Subject: Response to Review Comments
Geologic Hazards Evaluation and Preliminary Geotechnical Investigation
Rowley Property
Marksheffel Road and Colorado Tech Drive
El Paso County, Colorado
CTL|T Project No. CS20042.000-115

CTL|Thompson, Inc. (CTL|T) prepared a Geologic Hazard Evaluation and Preliminary Geotechnical Investigation (CTL|T Project No. CS20042-115, dated May 11, 2026), for the Rowley Property.

**Location of
 Exploratory
 Borings**

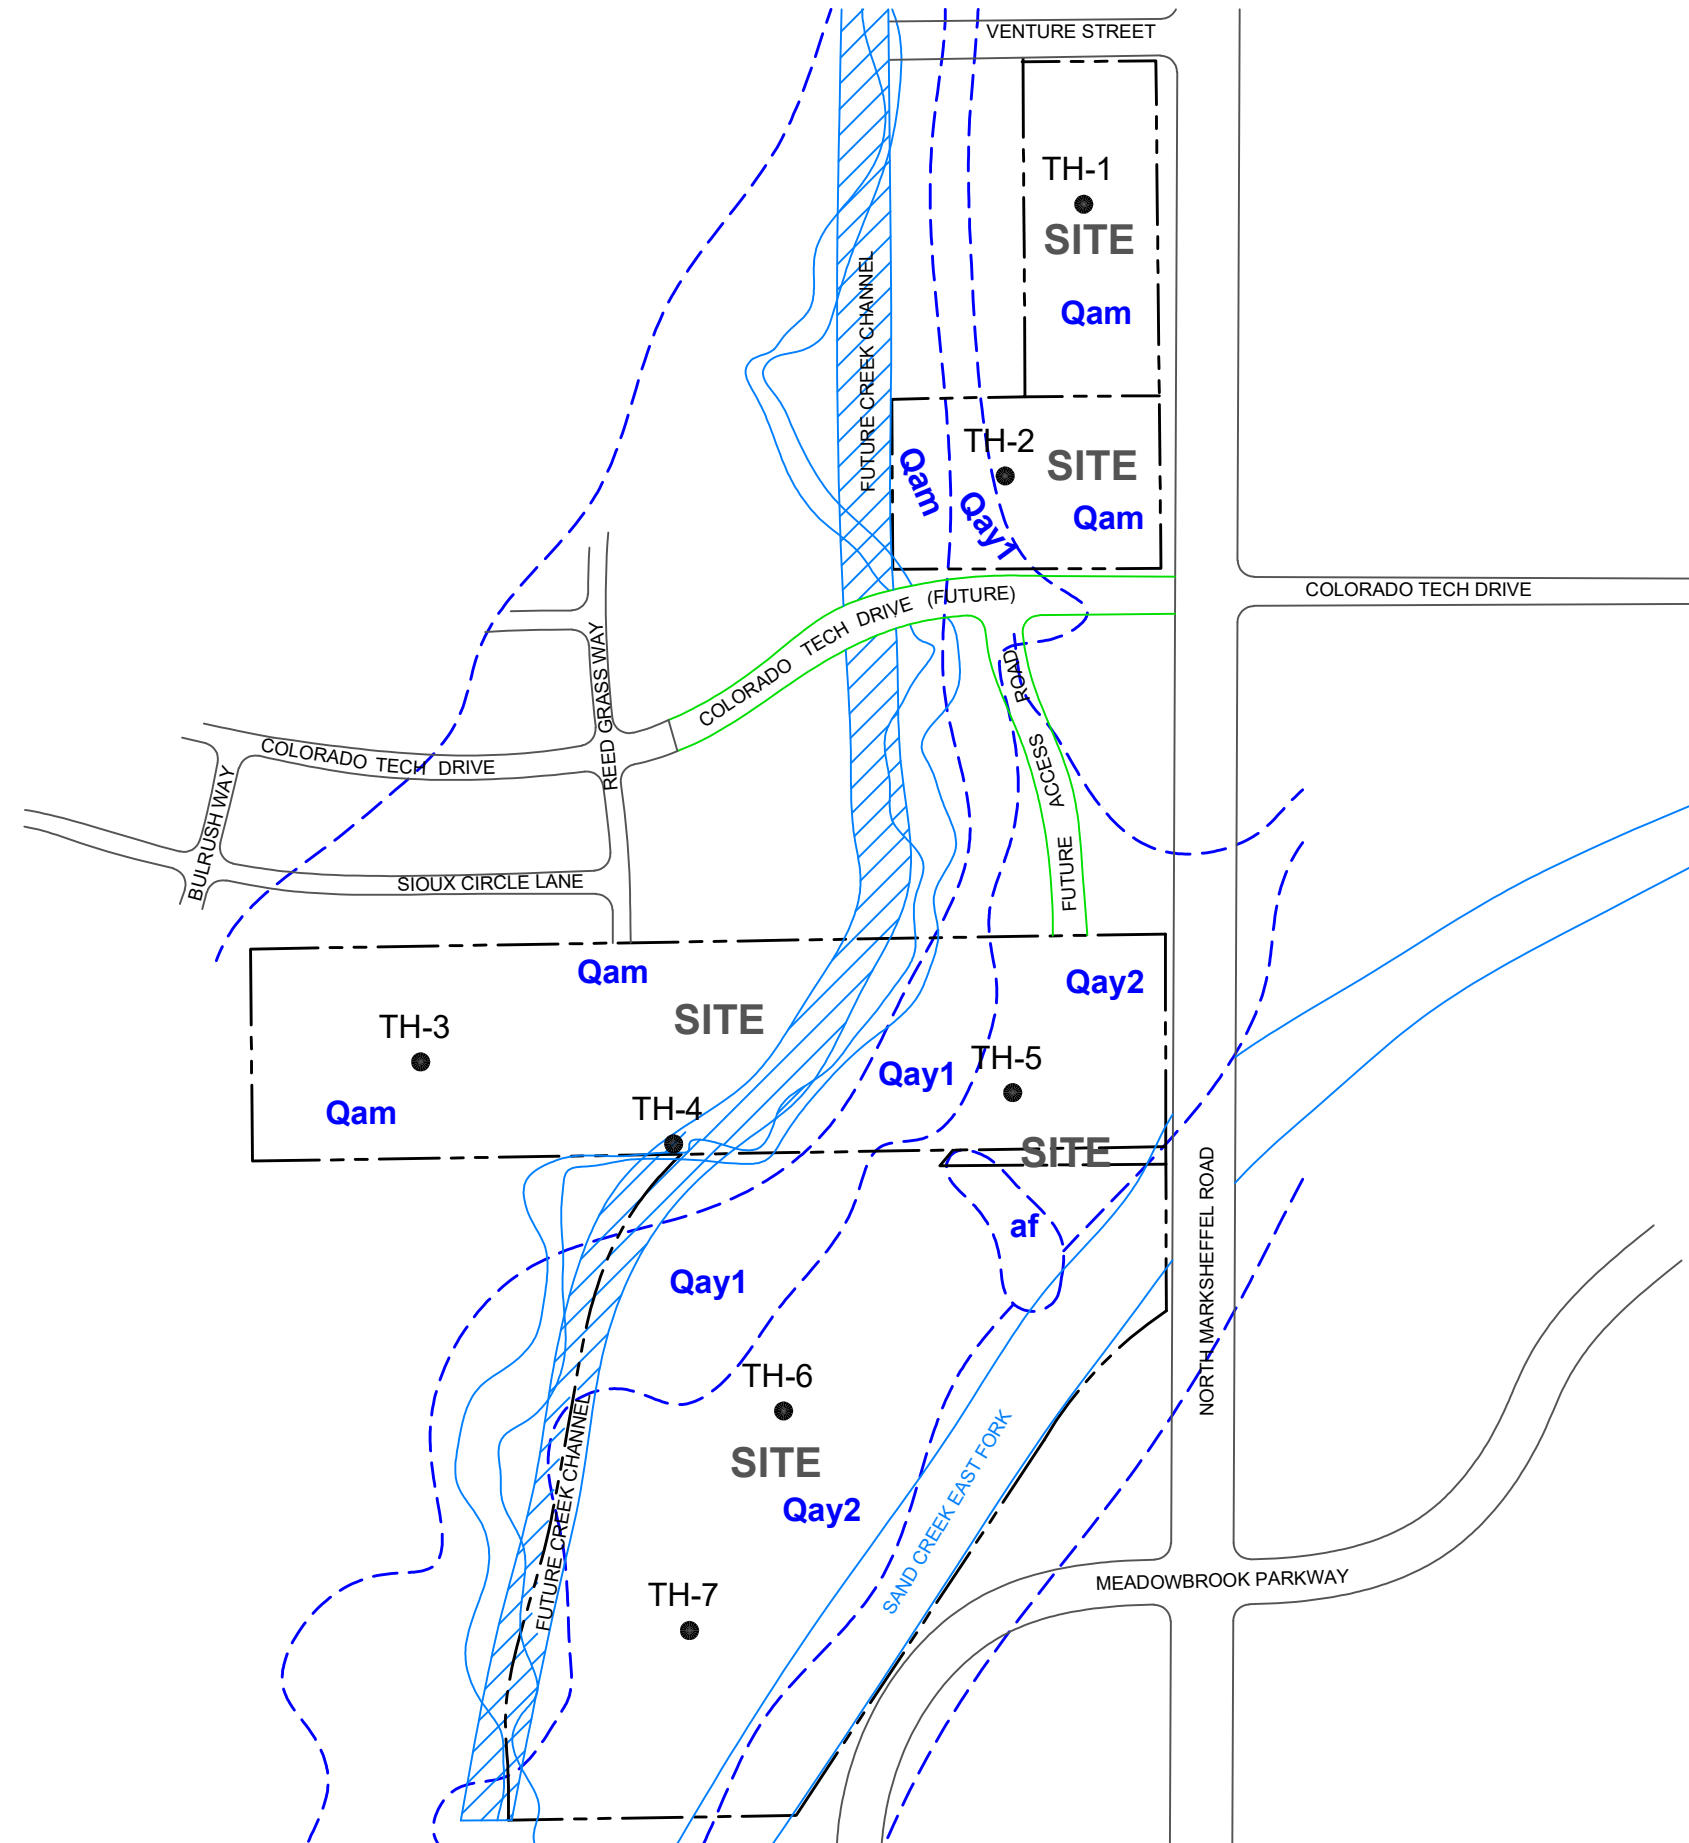
1. *"Include a Vicinity Map"*
2. *"Include a map for potential geologic hazards"*
3. *"Include soil map"*

1. A vicinity map of the site is presented in Fig. 1 of our report.
2. Our Fig. 3 titled Engineering Conditions presents the potential geologic hazards identified by our office. Our updated Fig. 3 is attached.
3. Our Fig. 2 titled Surficial Geologic Conditions presents our interpretation of the subsurface soils at the site.
